Memorandum

Date: September 29, 2023
Revised: November 29, 2023

Re: **MC3 Event Venue – El Paso County, CO**
Traffic Letter; PCD File No. AL2326

Conceptual Site Plan

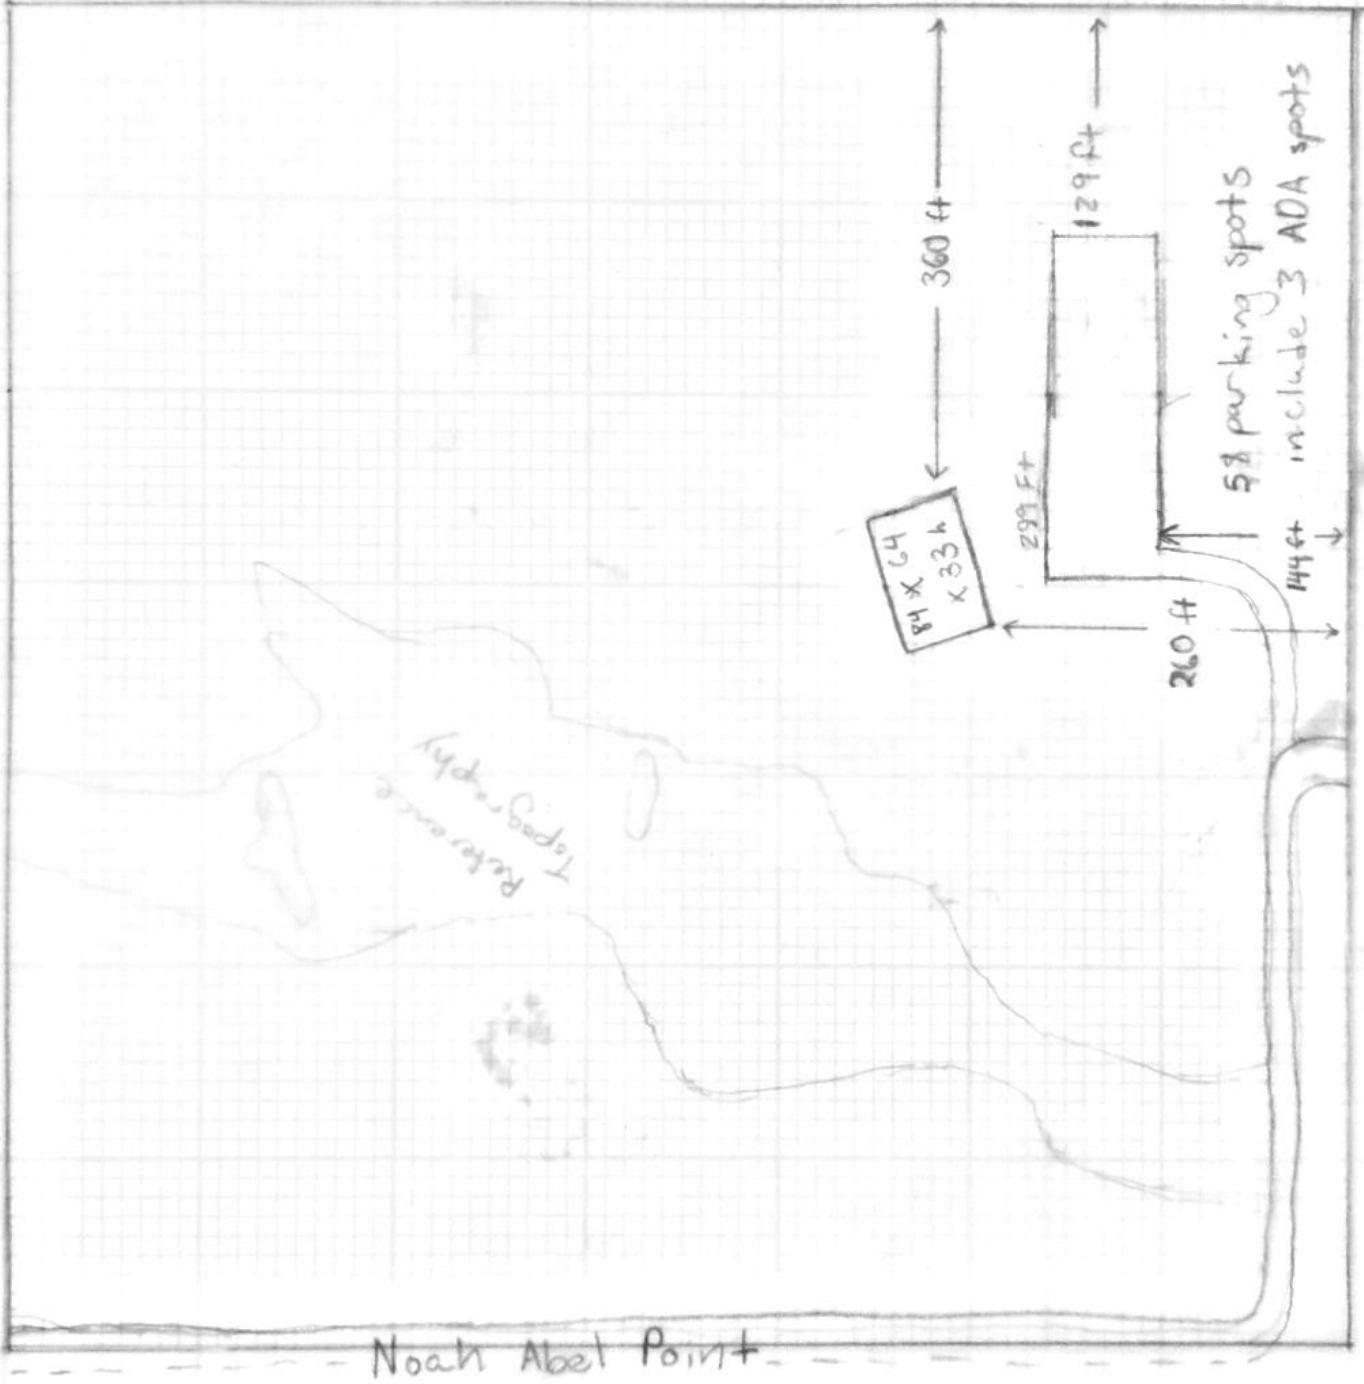
Provide correspondence from CDOT that determines what will be required for this development. Highway 24 is CDOT jurisdiction, so provide correspondence that states whether an access permit and improvement will be required. Reference CDOT access code 3.5 and determine if turn lanes will be required based on that criteria.
